Application No: A/253/21/OUT
Site Address: Land between 32 Downs Way and 2 Ambersham Crescent Angmering BN16 1AB
Description of works: Outline planning application with all matters reserved for the erection of 1 No bungalow dwelling with off street parking and private amenity space.

Thank you for your internet representation made on 18th January 2022 which has been recorded as an objection with the comments as follows:

Indicative Plans and Elevations

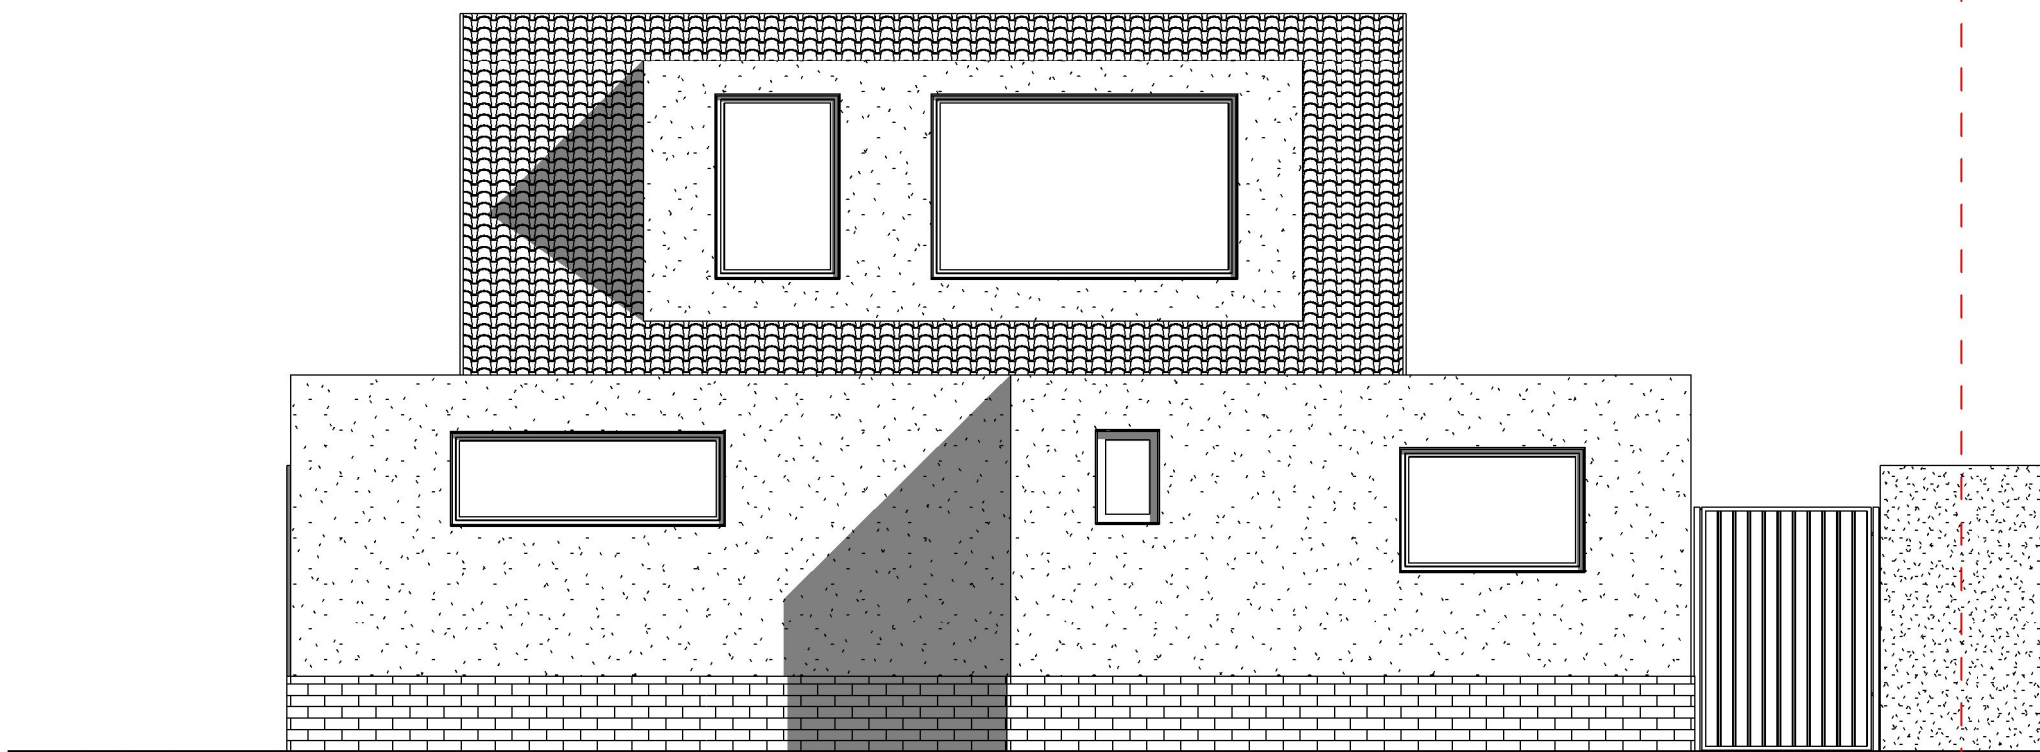
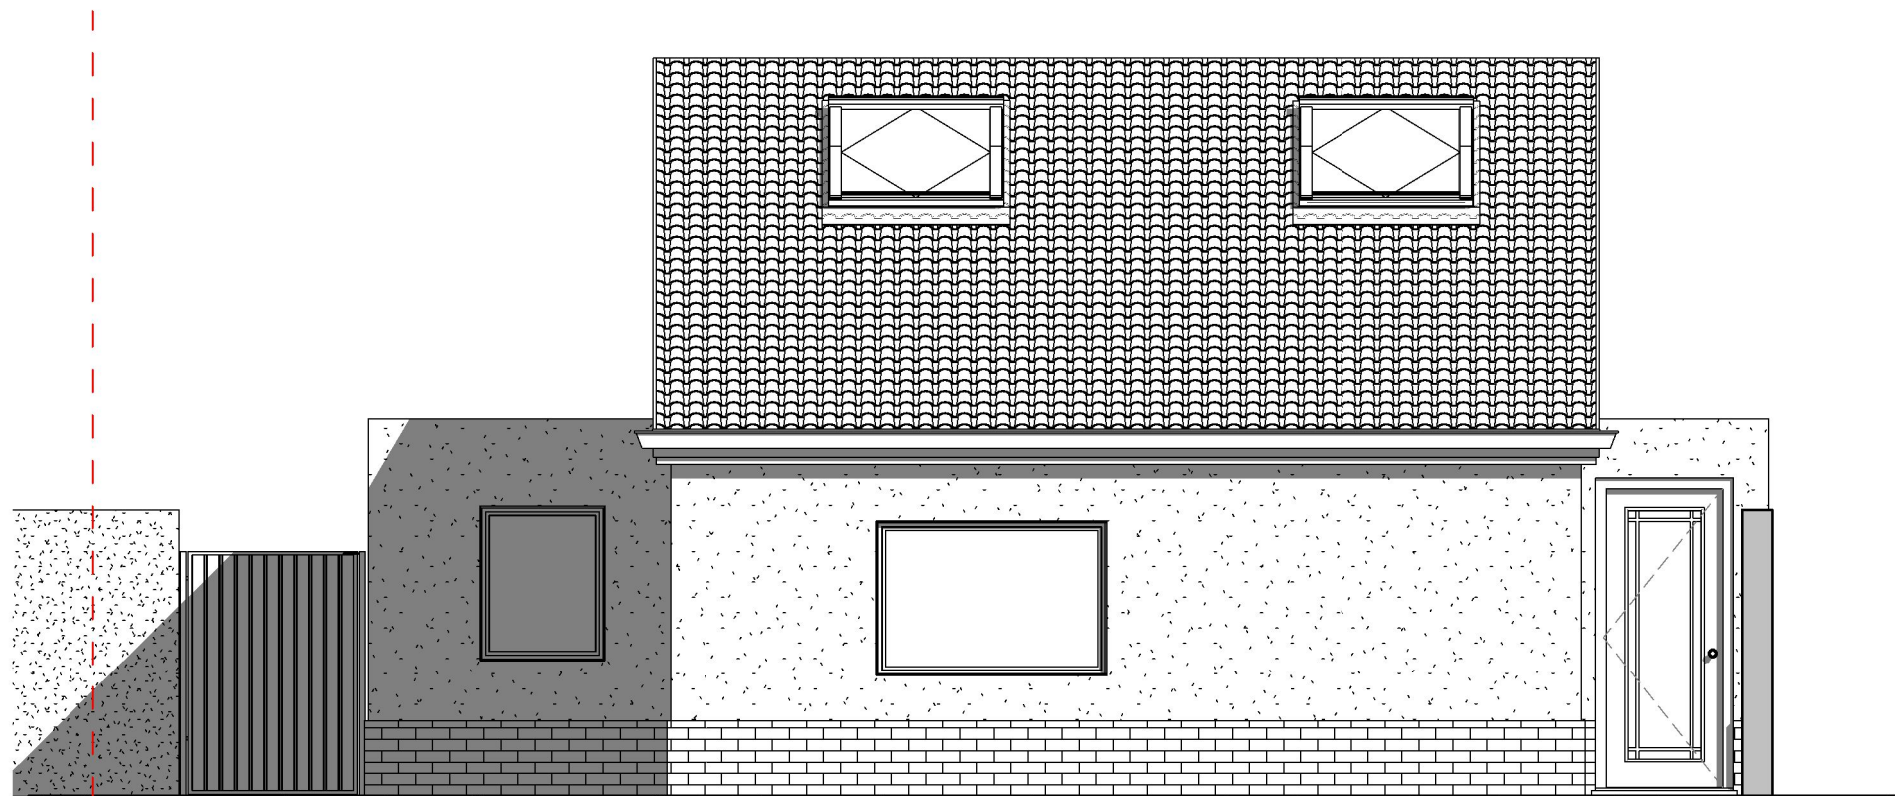
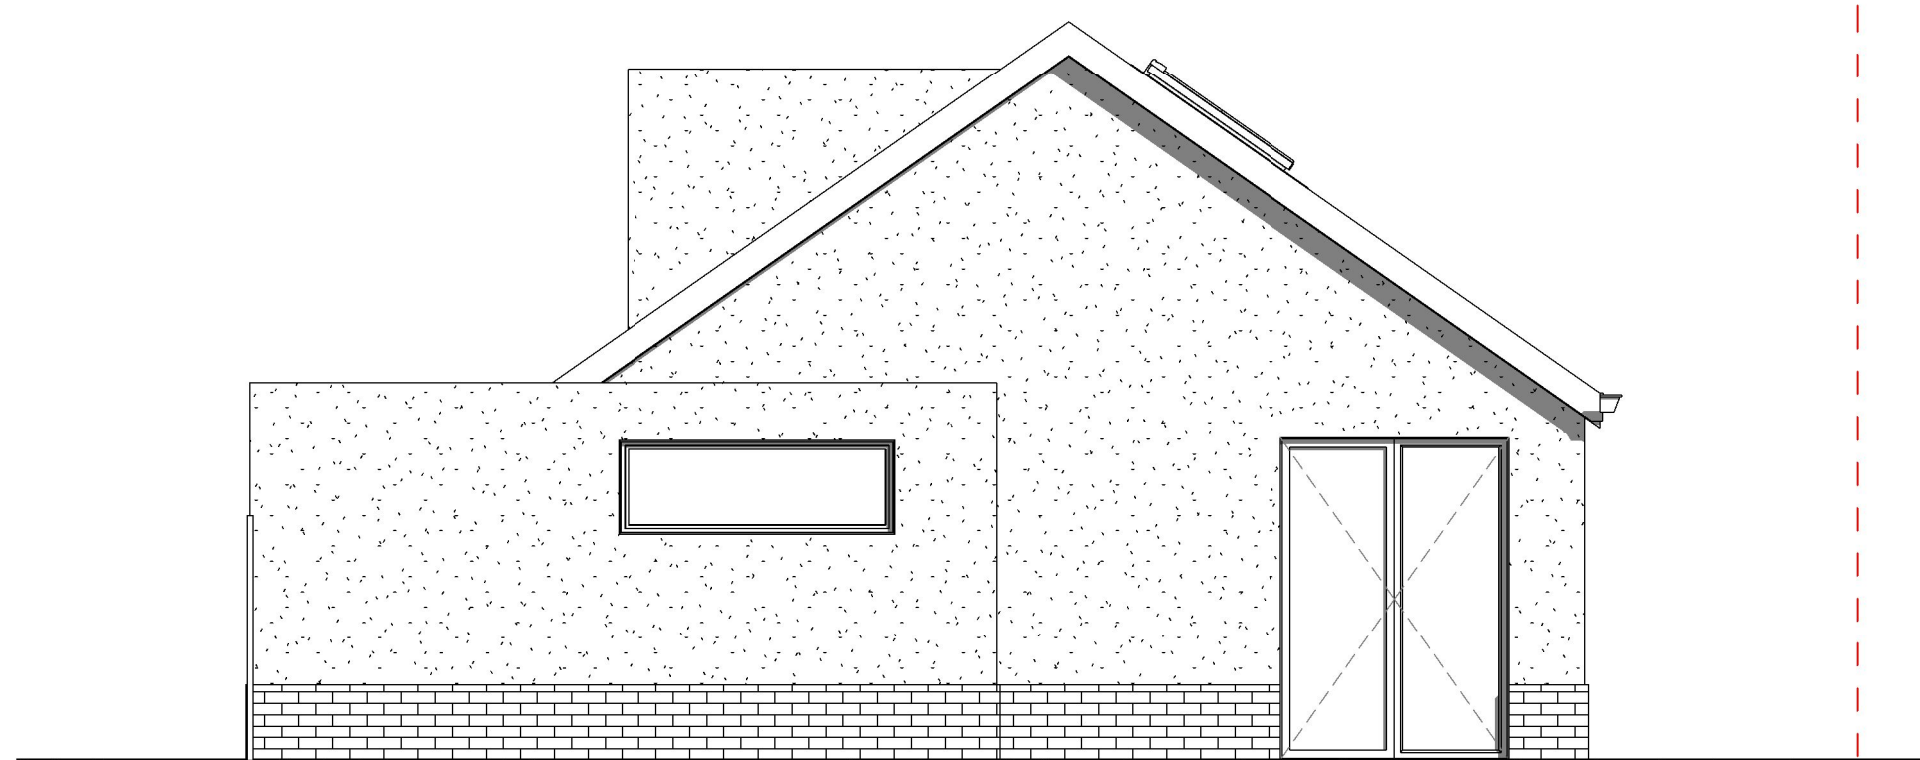
- 2) This application shows a bungalow with flat roofs which is out of keeping with the neighbouring properties.
- 3) Angmering has enough major builds going on without taking away yet another tiny small green space . This space also accommodates a small bench which our elderly residents use to stop for a rest between shops and there homes. Will they now have to struggle ?
